James Archdale - Submission: White Rocks Wind Farm Application Number MP 10_0160

From: "Greg Williams" <gwilliams@nbntv.com.au>
To: <james.archdale@planning.nsw.gov.au>
Date: 6/07/2011 12:06 PM
Subject: Submission: White Rocks Wind Farm Application Number MP 10_0160
CC: <dwright@nbntv.com.au>, <CPaterson@nppower.com.au>, <mdonnelly@gisc.nsw.gov.au>, <Ron.Roosmalen@scmedia.com.au>, <David.Searle@prime7.com.au>, "George Hird" <ghird@nbntv.com.au>

$Figure\ 1-Map\ of\ Communications\ Link\ and\ White\ Rock\ Wind\ Farm$

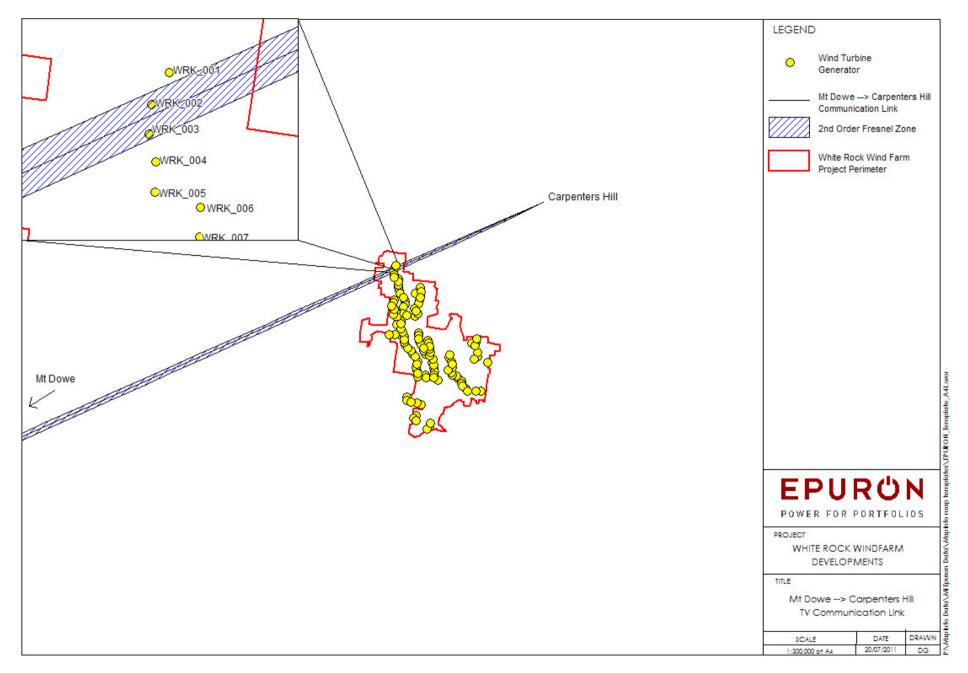
I am quoted in the Environmental Assessment document, appendix 6, section 4.1. Unfortunately this information is now invalid as the locations of the wind turbines have changed and several units are now in the direct line or within the first Fresnel zone of the signal passing through that area. The interference research done by the proponent is quite correctly based on ITU-R BT.805. I refer to paragraph 2 of page 11 of the Environmental Assessment:

This is a similar situation that we find ourselves facing. The Environmental Assessment document does not describe the effects of wind turbine blade rotation on a digital television signal but from our experience it potentially could result in a complete loss of input signal to the re-Transmitters due to their inability to regain a locked condition due to the cyclic nature of the interference, should it occur. This also applies to viewers receiving the signal directly from Mt Dowe. Should the interference prove to be above acceptable limits for the operation of the digital television re-Transmitters used at Carpenters Hill the people of Glen Innes could be without commercial television until it is rectified. Typically this could take from weeks to several months. Obviously a very unacceptable situation.

While it is recognised that the major impact to our input signal will be from the Glen Innes Wind Farm project, any mitigation planning by the Glen Innes Wind Farm to overcome their interference problem could be negatively impacted by the White Rocks Wind Farm interference.
